Ref/Job No: **18SYD-9618**

22 March 2019

Re: OEH Submission to Eastern Creek Business Hub SSD 5175 Modification 4 - Biodiversity Impacts

### Proposed changes to drainage and road layout

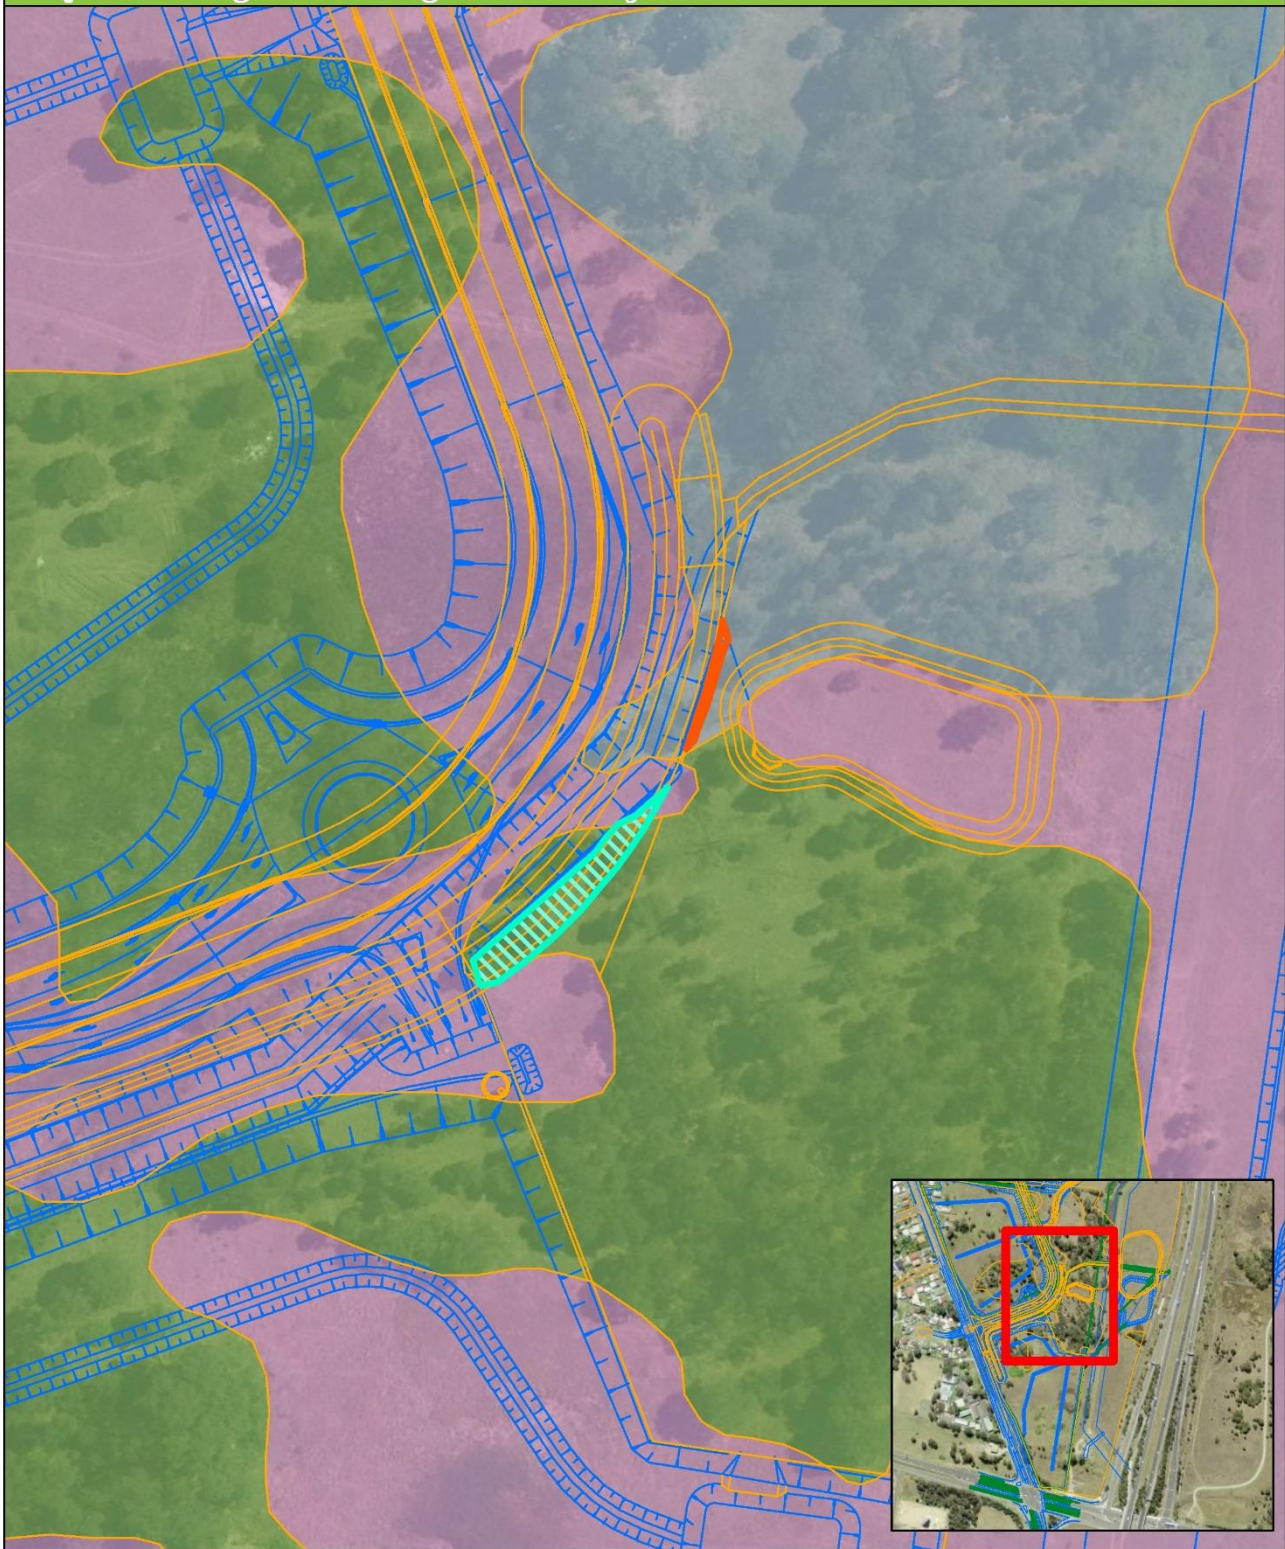
OEH required clarification on whether the proposed changes would impact on an offset area.

Additionally, as per **Biodiversity 1**, OEH have noted that previous mapping was not clear in its intention/description of change to impacts.

In response to the fact that the proposed modification involved minor additional impacts to vegetation within the ECA, being 0.002 hectare loss of Alluvial Woodland, Frasers Property Australia have redesigned the stormwater channel batters to remove said impact. This redesign means that the Modification now only involves a *reduction* in impacts to Shale Plains Woodland (SPW).

As requested, **Figures 1 and 2** below have been prepared to provide greater clarity around the change in impacts and clearly depict the updated design. Further, **Appendix 2** now provides previous mapping to give context to the current changes and proposed reduced impacts.

Figure 1 – Provides clarity around the decreased impact to Shale Plains Woodland (SPW) and the removal of any impacts on Alluvial Woodland (AW), providing decrease in impacts to native vegetation.
